RE: Hope Christian Elementary (Proj.
1008415) For your DRB Hearing on
09/01/10

5. **Project# 1008415**
10DRB-70191 MAJOR – SITE
DEVELOPMENT PLAN FOR
BUILDING PERMIT

10DRB-70191 MAJOR – SITE DEVELOPMENT PLAN FOR BUILDING PERMIT

Re: Hope Christian Elementary School Addition Project (1008415)

**SCHOOL OFFICE
ELEVATION PLAN**

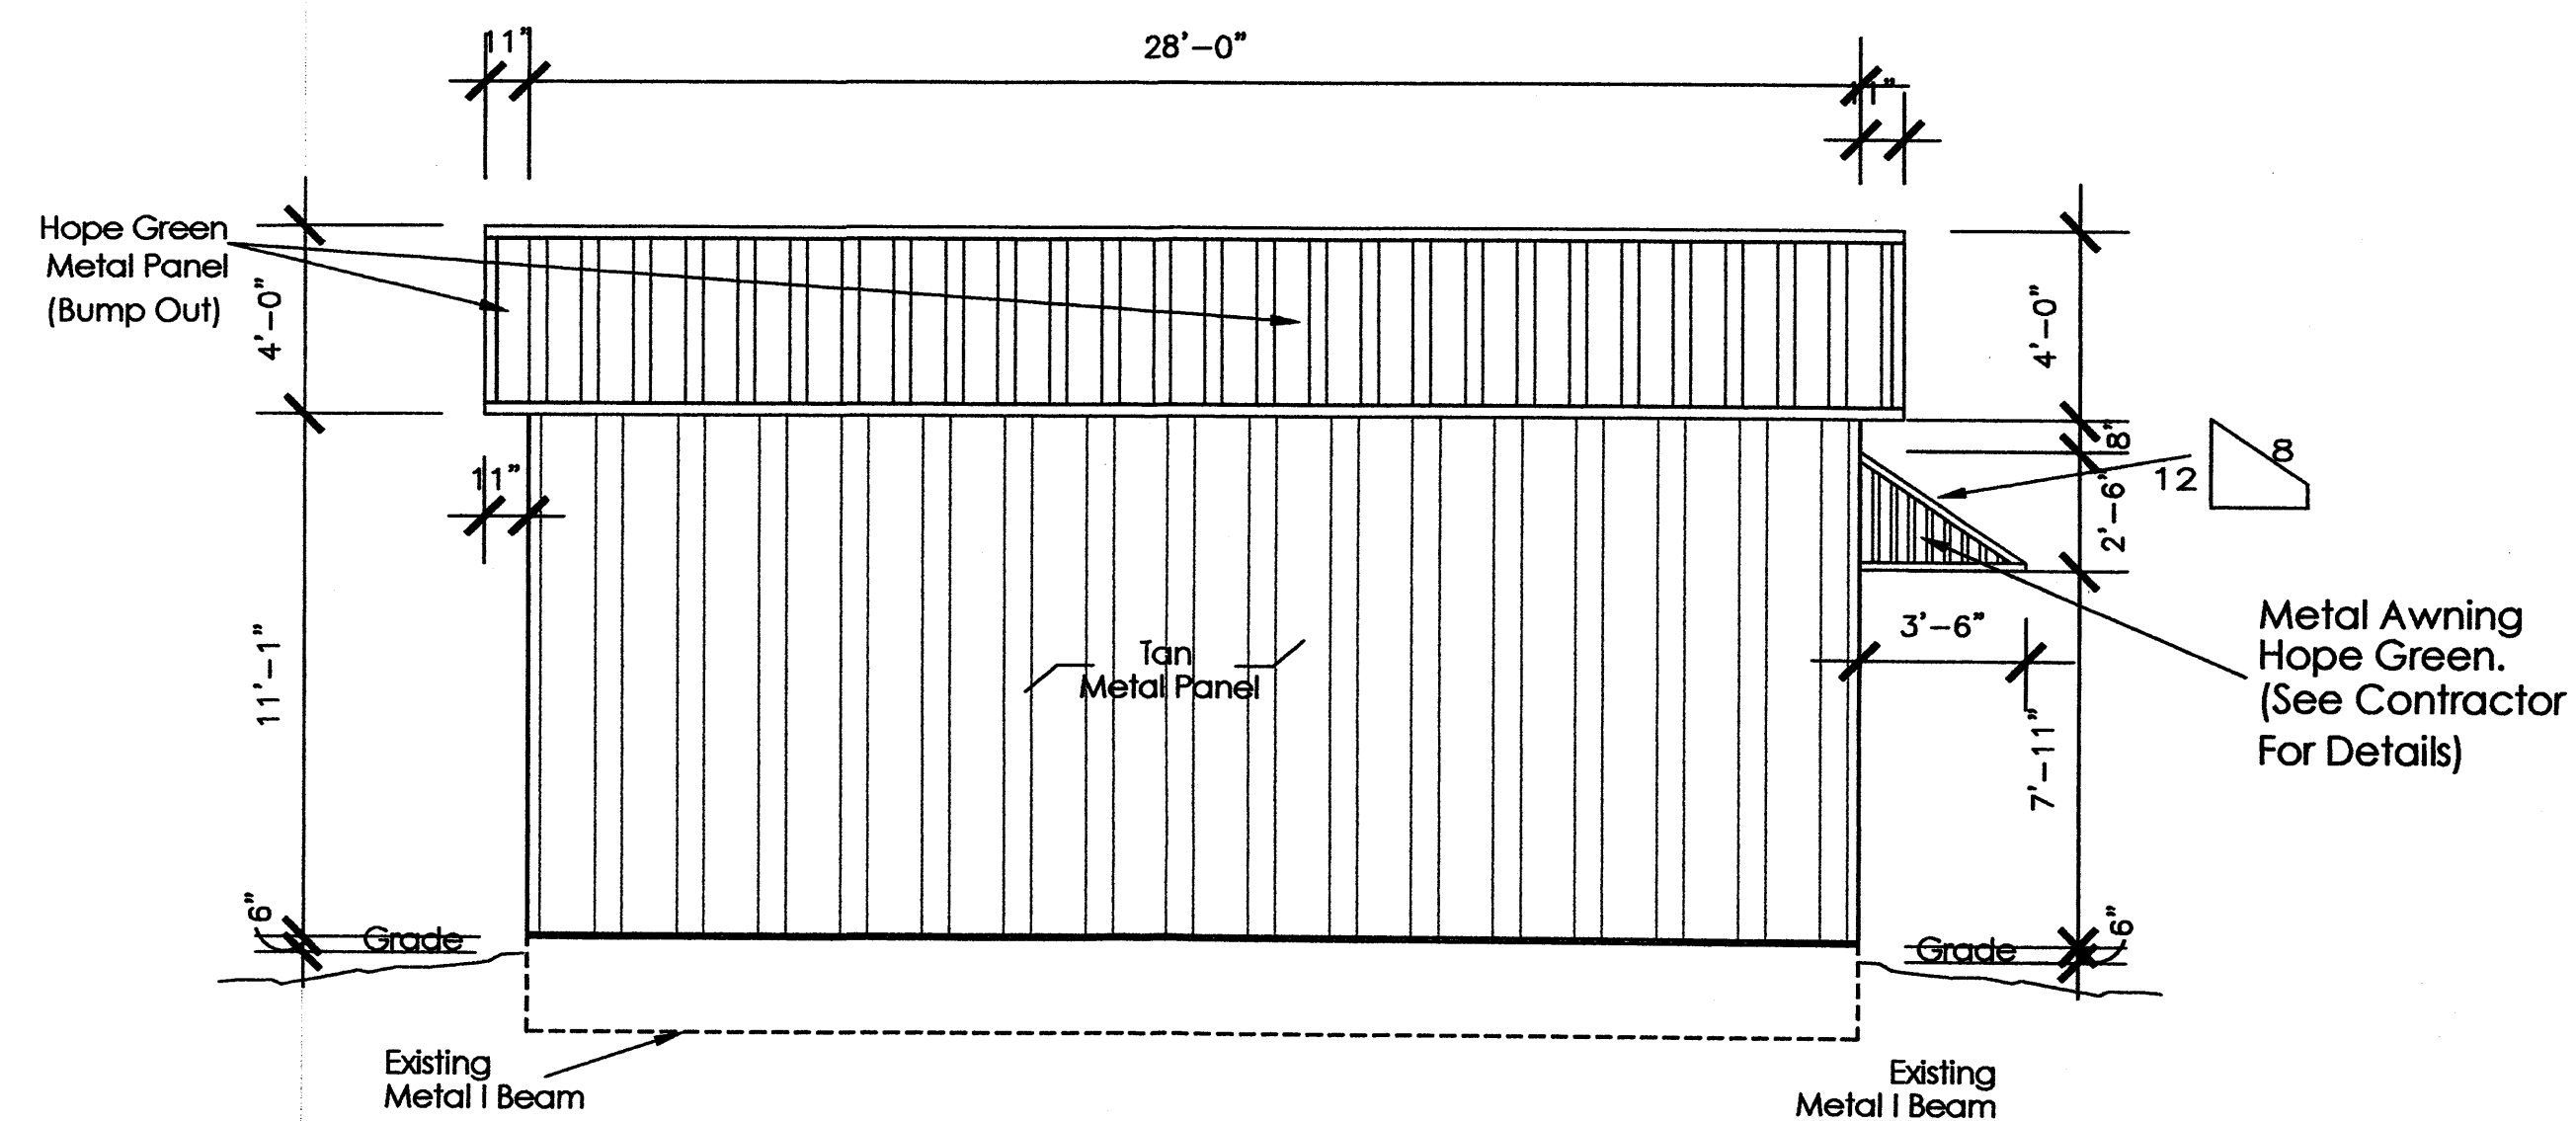
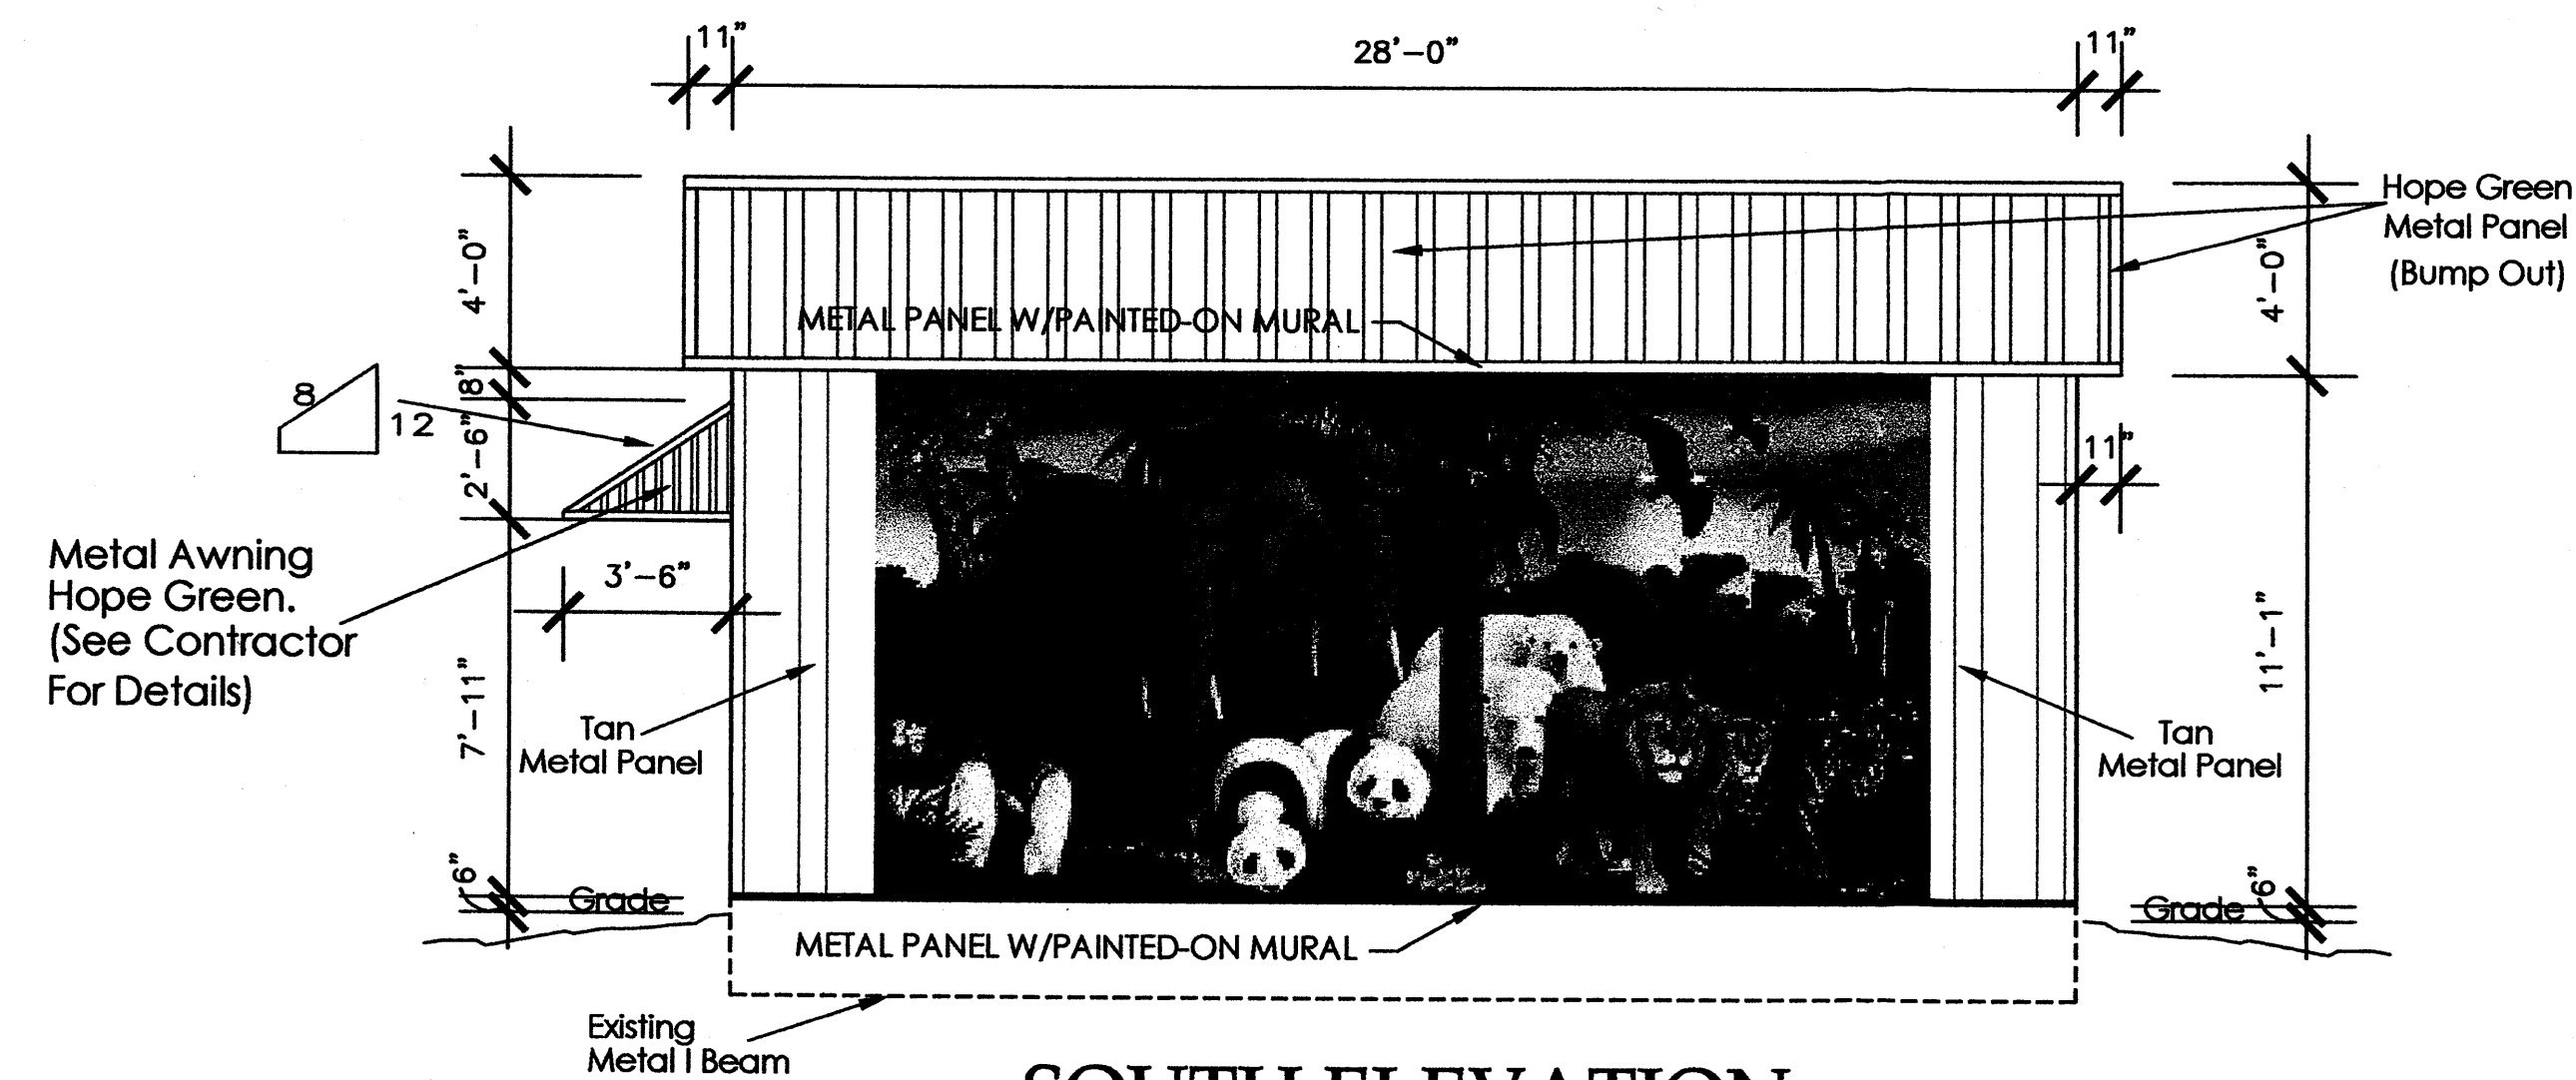
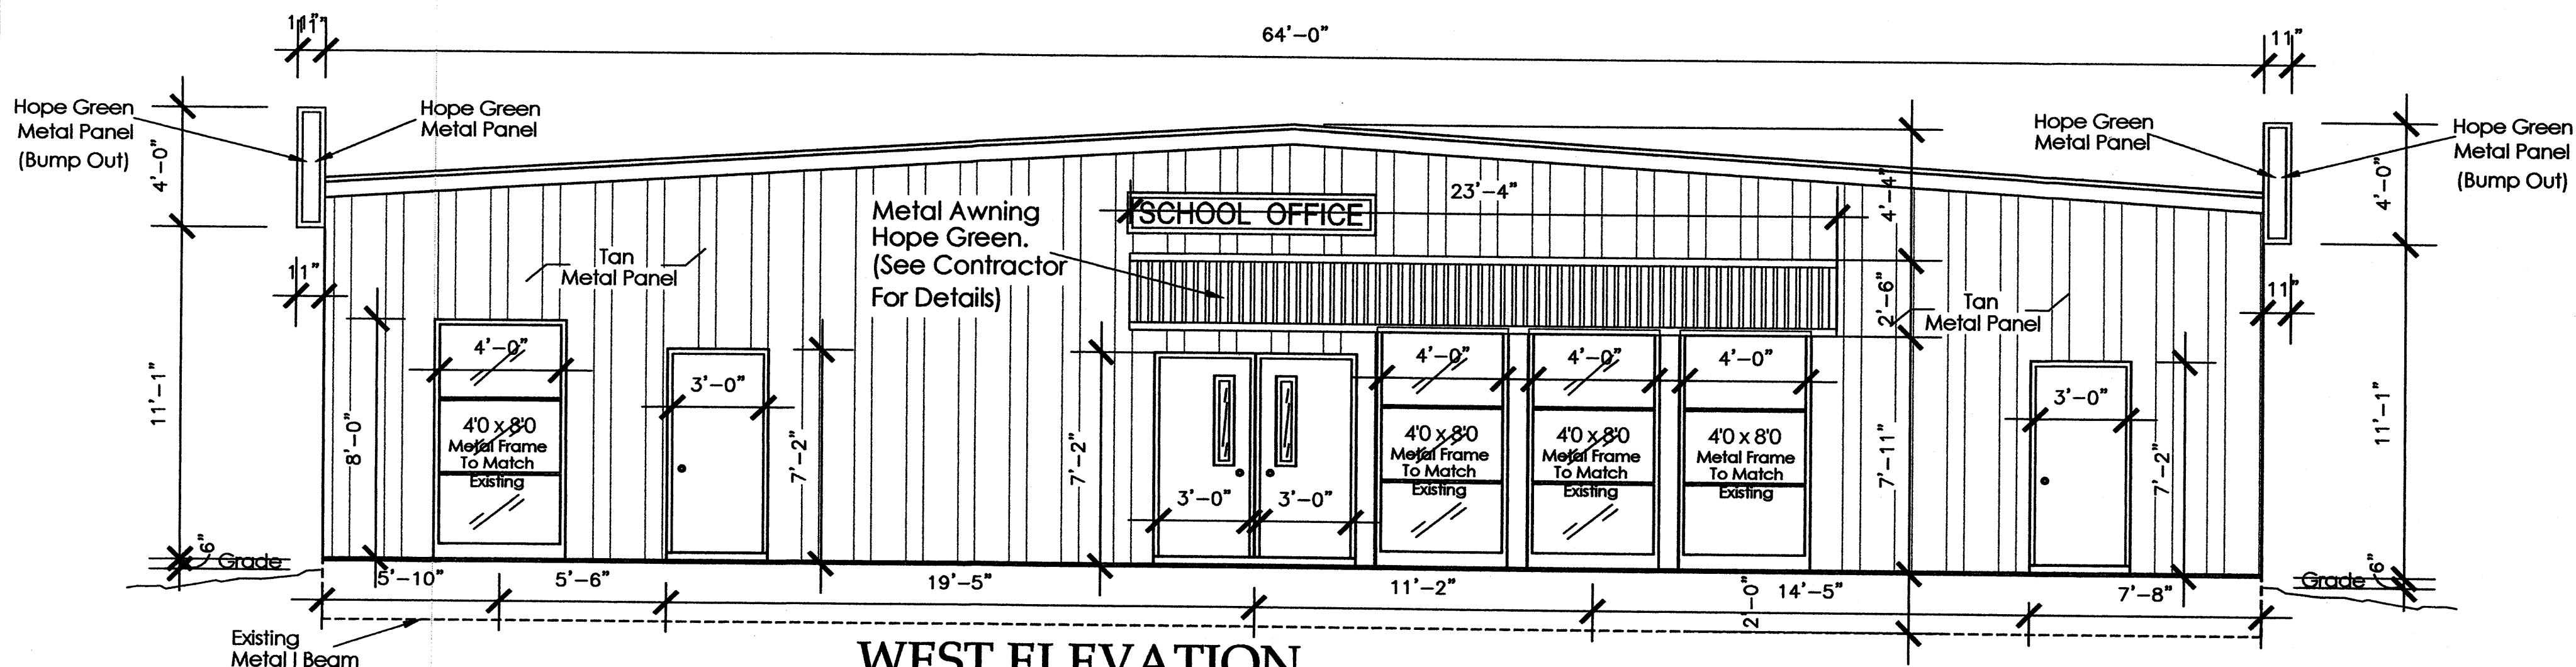
AMAFCA No comments.
COG No comments.
TRANSIT No comments
ZONING ENFORCEMENT The North I-25 sector plan has been revised. There now design guidelines in place that must be followed for new buildings. Page 35 b) 1. Building entrances shall be articulated with an awning, arcade change in roof line or similar element to create a sense of entry. Page 36 b) 2. The library should be brought in line with the example of articulation shown. Page 36 d) 2. Building facades shall be required to use a minimum of 2 different finishes. all accessory buildings shall be of the same materials used in the primary building design. One motorcycle parking space is required.
NEIGHBORHOOD COORDINATION Letters sent to: No Neighborhood and/or Homeowner Association(s)
APS This will have no adverse impacts to the APS district.
POLICE DEPARTMENT No comments.
FIRE DEPARTMENT No comments.
PNM ELECTRIC & GAS No comments.
COMCAST No comments.

The building elevations have been redrafted by Architect Ron Montoya to show entry awnings and a color mural for the buildings fronts, in response to previous comments by Zoning.
